George Hotel

26.07.08 - S19 Variation – Overview Report

(Variation under Section 19 of “*Planning (Listed Buildings and Conservation Areas) Act 1990*”)

- LBC ref: 2025/65/91148/W - dated 24.10.25
- Superseded (Conditions) by Variation: 2026/70/90462/W - Conditions (and scheduled drawings) dated 11.05.26

RF Level RF - Roof Demolition Plan
1 : 100

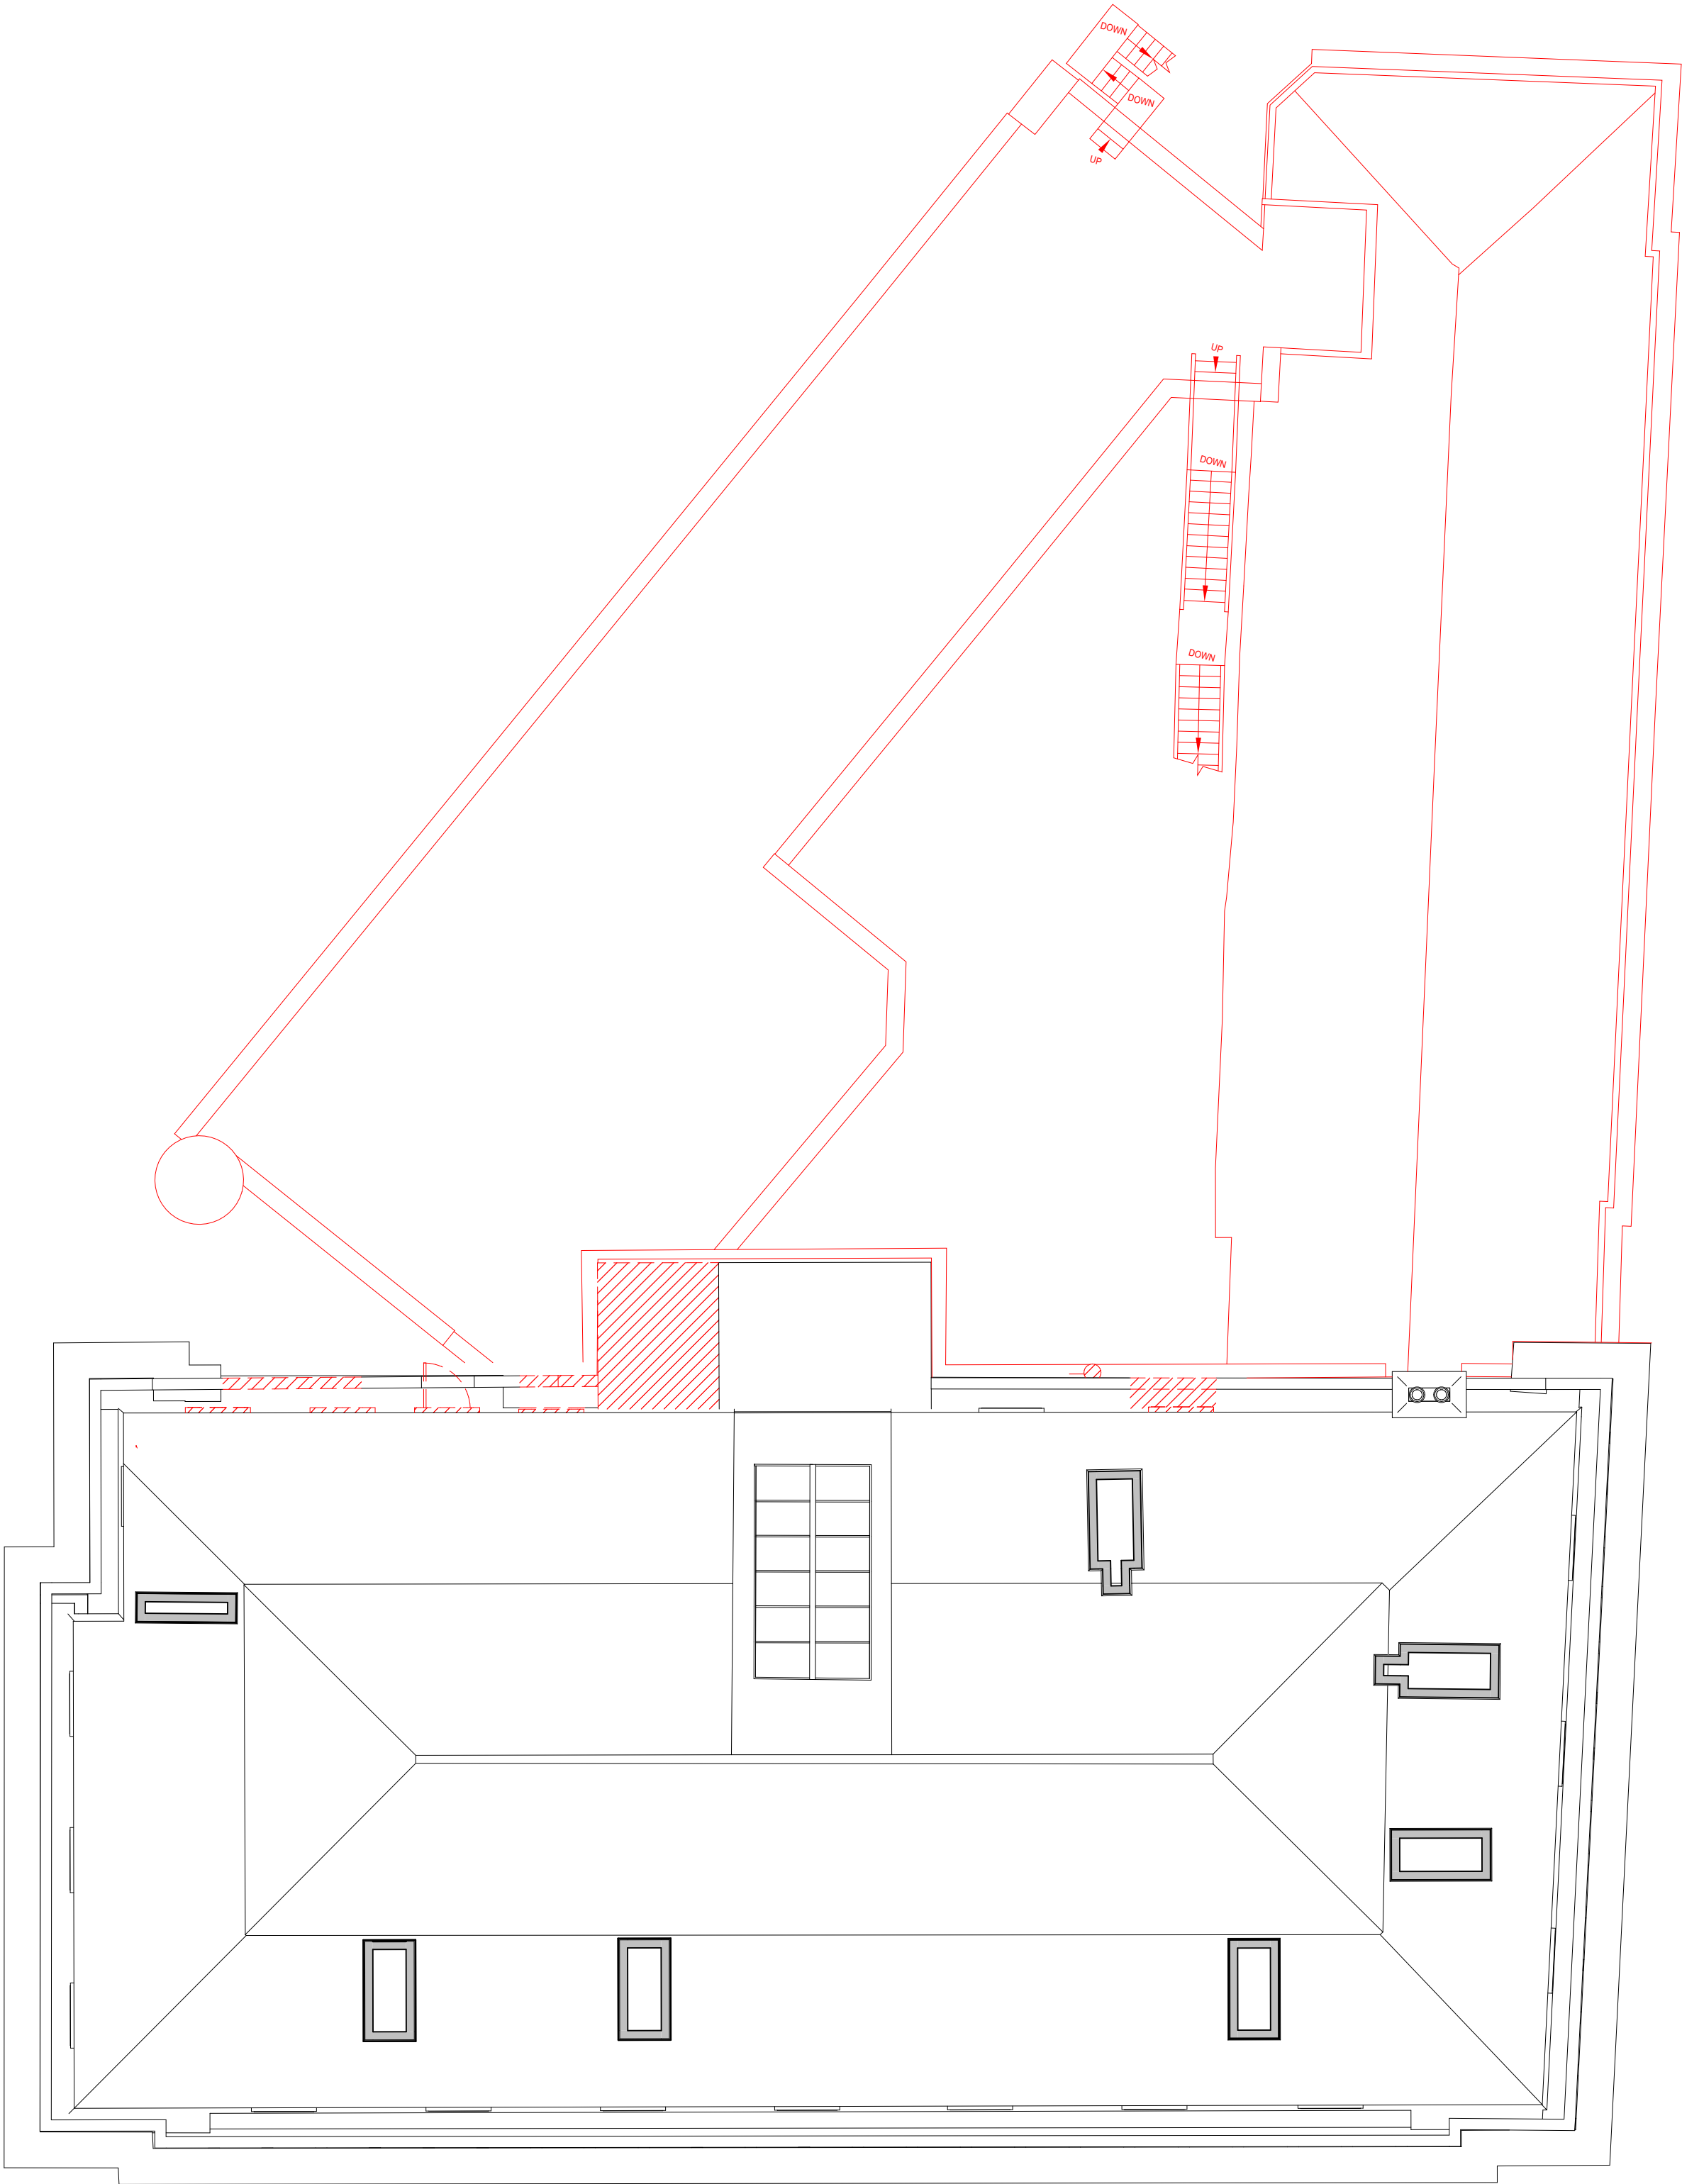
1. Rooftop plant enclosure and plant screen reconfigured to provide acoustic screening to rooftop plant.
2. Ventilation grilles added to Block A as a result of the MEP ventilation strategy developing through to stage 4.
3. Additional ventilation grilles added to JWS as a result of the MEP ventilation strategy developing through to stage 4.
4. Plinth added to west elevation of new build to raise cills above damp proof course.
5. Plinth added to east elevation of new build to raise cills above damp proof course.

01 Level 01 - First Floor Demolition Plan
1 : 100

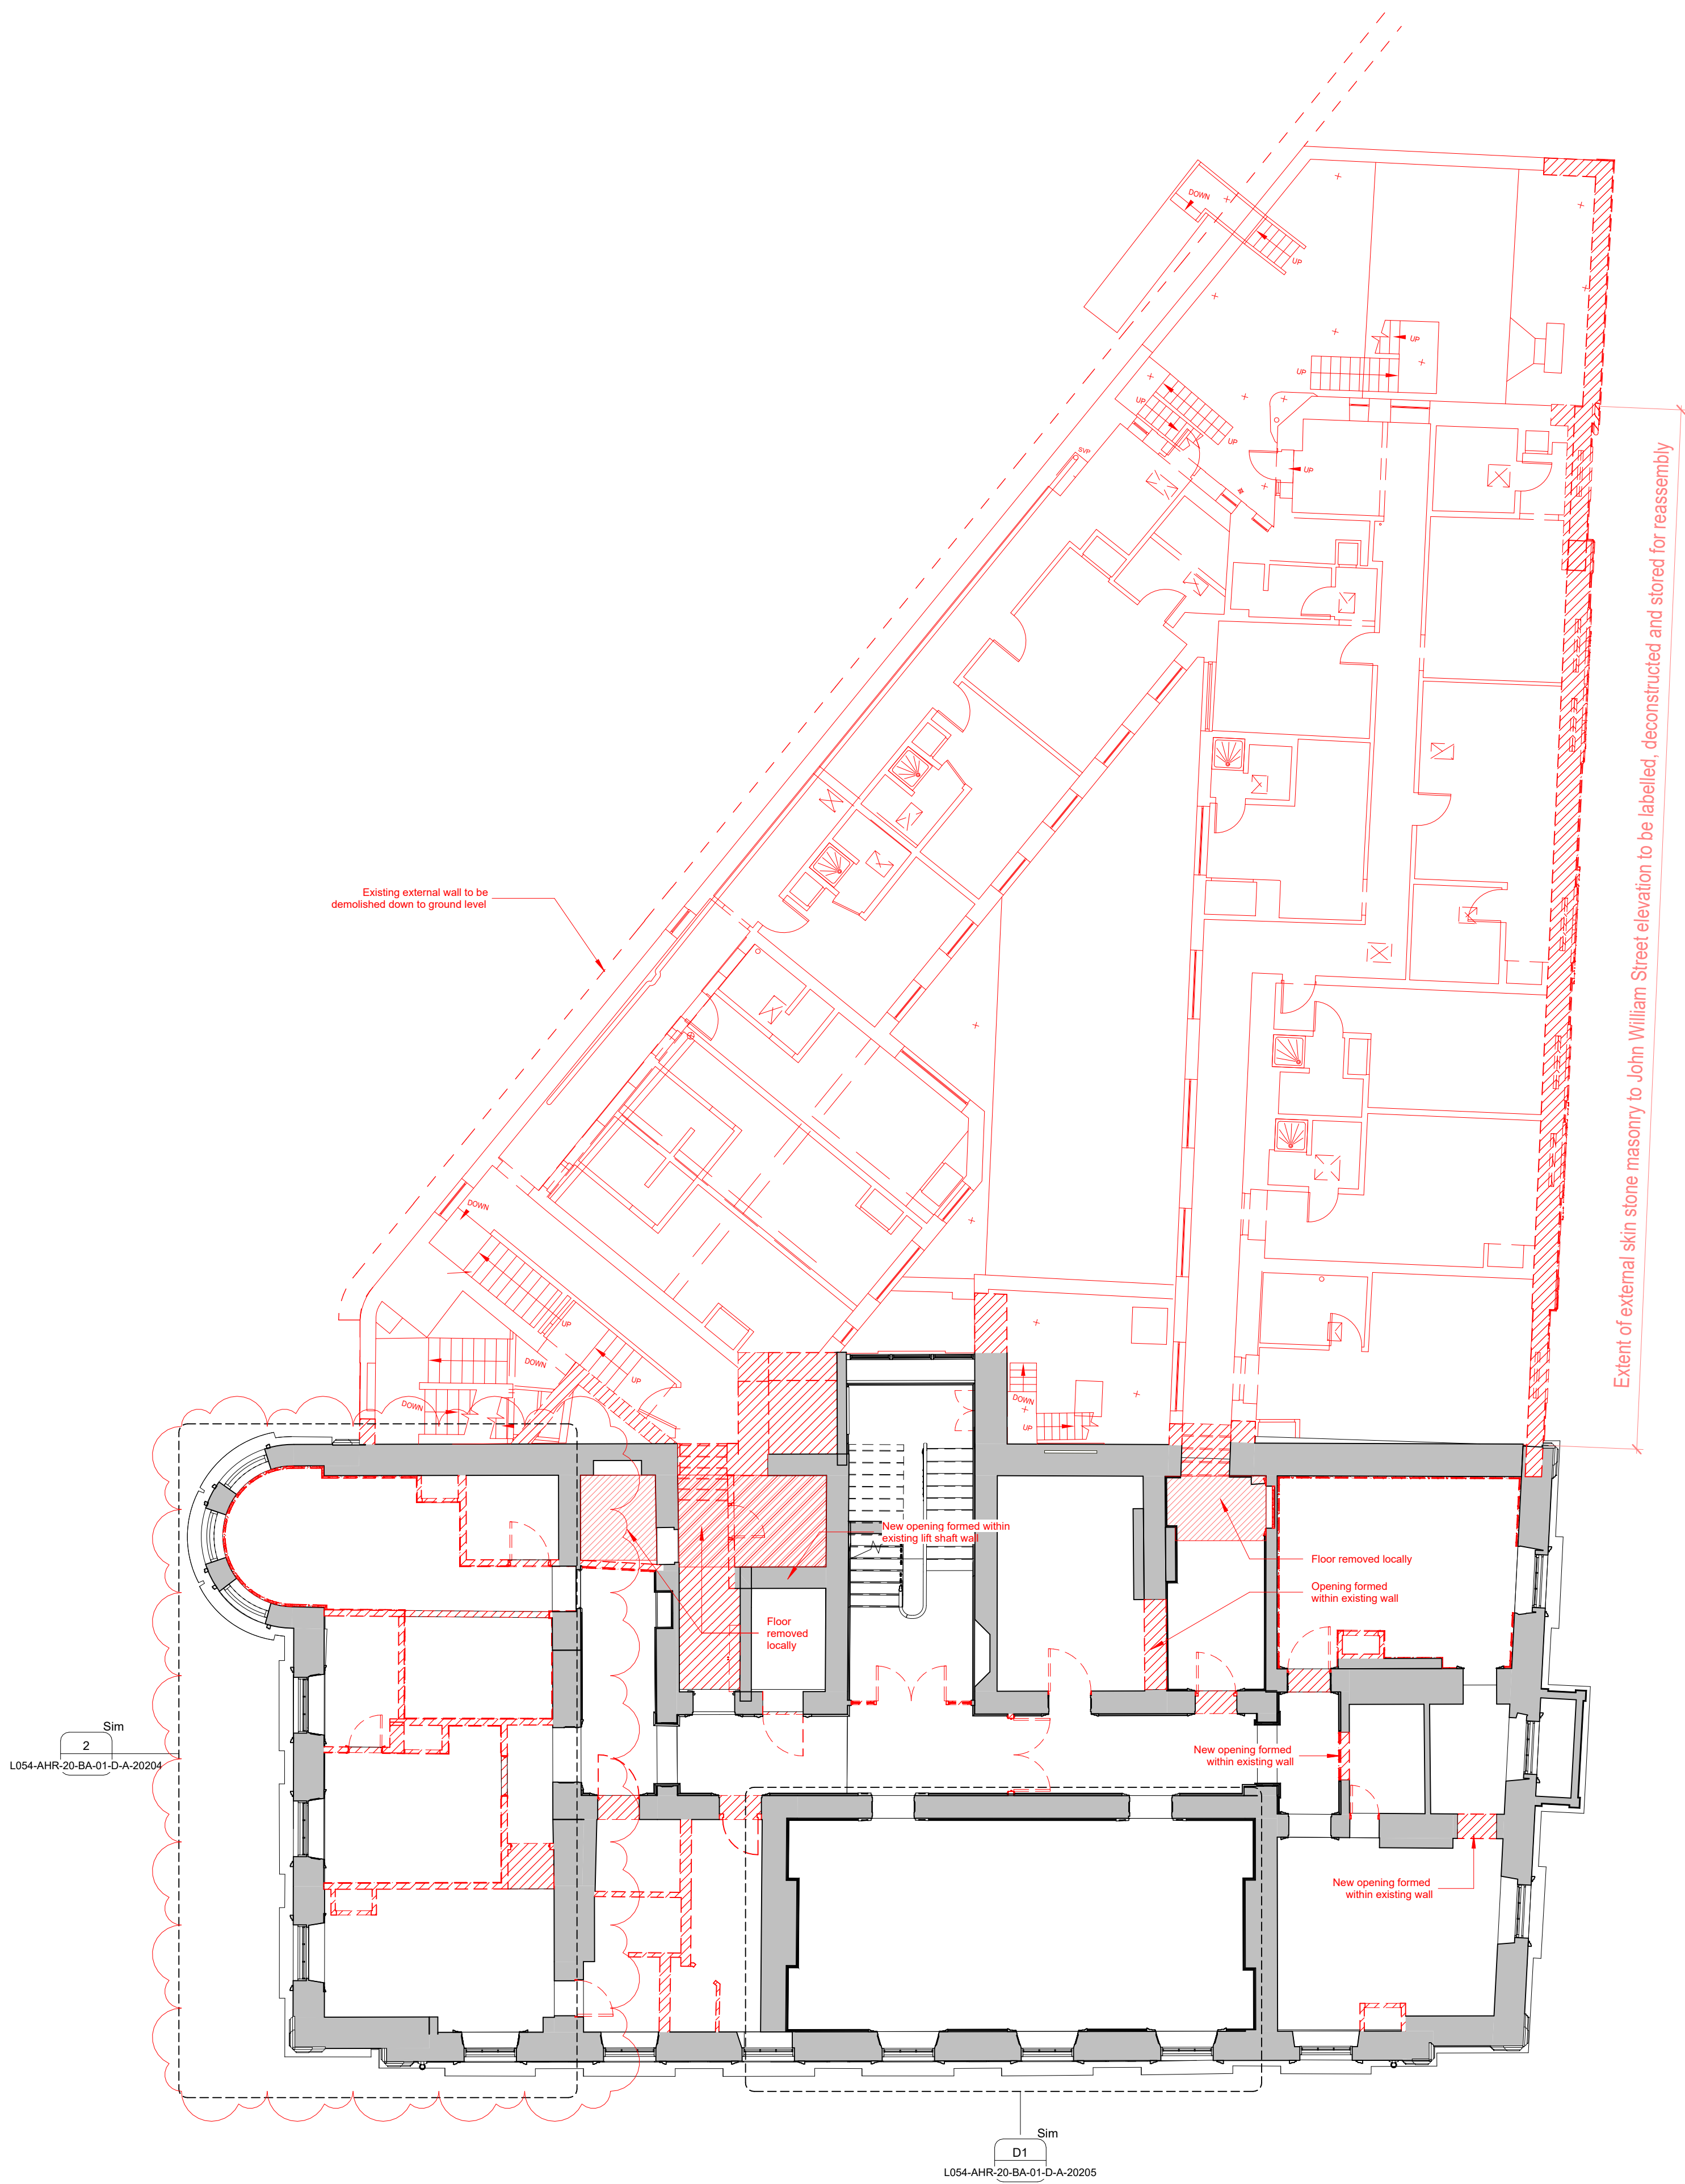
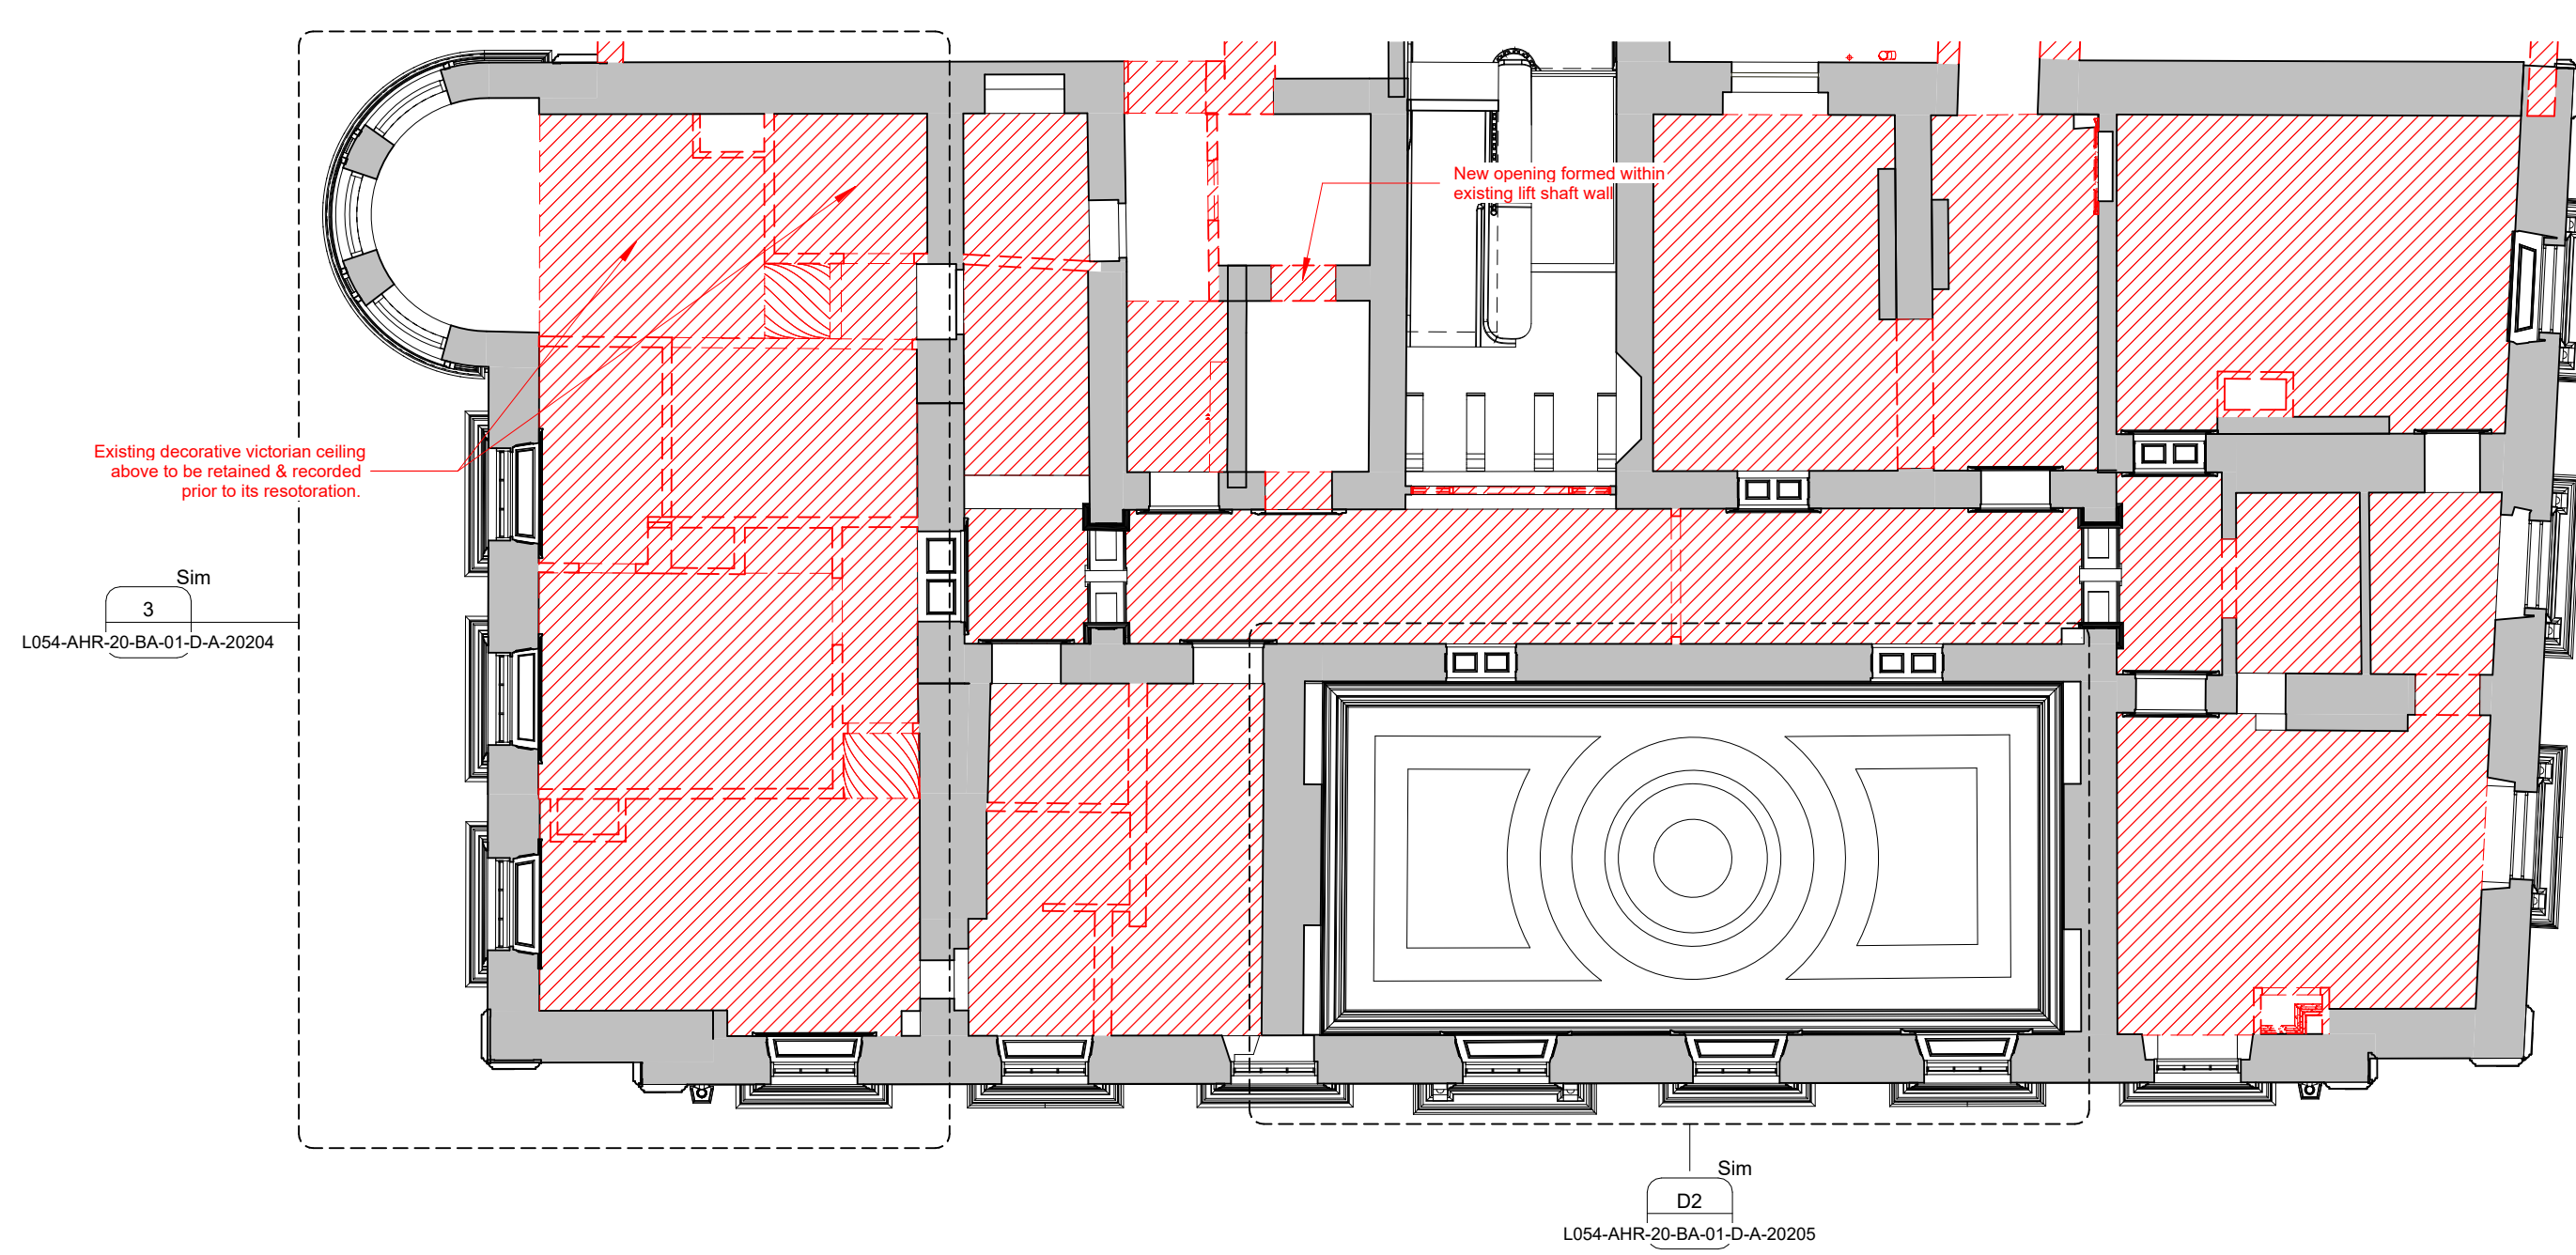
1. Rooms 062, 052, 053, 054, 055, 056, x26, 057, 059, 060, 051, 094, 093, 092, x38, x39, x37, 095 & 091 Reference to floor & ceiling details for fire and acoustic enhancement updated to reflect existing condition following further investigations.

2. Miscellaneous notes updated to include MEP ventilation strategy and resultant grilles on the existing façade.
3. Fully glazed screen and fully glazed double doors between x39 (corridor) and x23 (main stair) omitted and replaced with plasterboard partition and timber doorset.

4. Fully glazed screens and fully glazed single doors forming fire lobby directly outside the existing lift within x39 (corridor) omitted and replaced with plasterboard partition and timber doorset.

5. High Significance Room – Former First Floor dining area comprised from Rooms 055, 056, 057, 059, 060 & X26. Following LBC & Soft strip works the removal of 1980s ceilings in this area has revealed a significant amount of the original former dining room ceiling plasterwork with cornicing & coffer detailing. It is noted this heritage ceiling has been damaged extensively over time via penetrations & historic adaptation with general condition poor. This exposure has been fully recorded by the appointed Level 3 recording (WYAAS sub) & inspected by the COs prior to investigations. The proposals include for the full retention of the section of ceiling in the bay window (restore in place), the scan recording & reinstatement of all cornice and coffer detail as existing but in Gypsum Plaster (fire compliance) but the ceilings uncovered in Rooms 055, 056, 057 & X26 are deemed in a material loss state (record and remove/ replace as per the standard Room to Room detail 2b on drawing ref “L054-AHR-20-BA-ZZ-D-A-20300_P6 - LBC Details - Block A Floor & Ceiling - Sheet 1.pdf”.
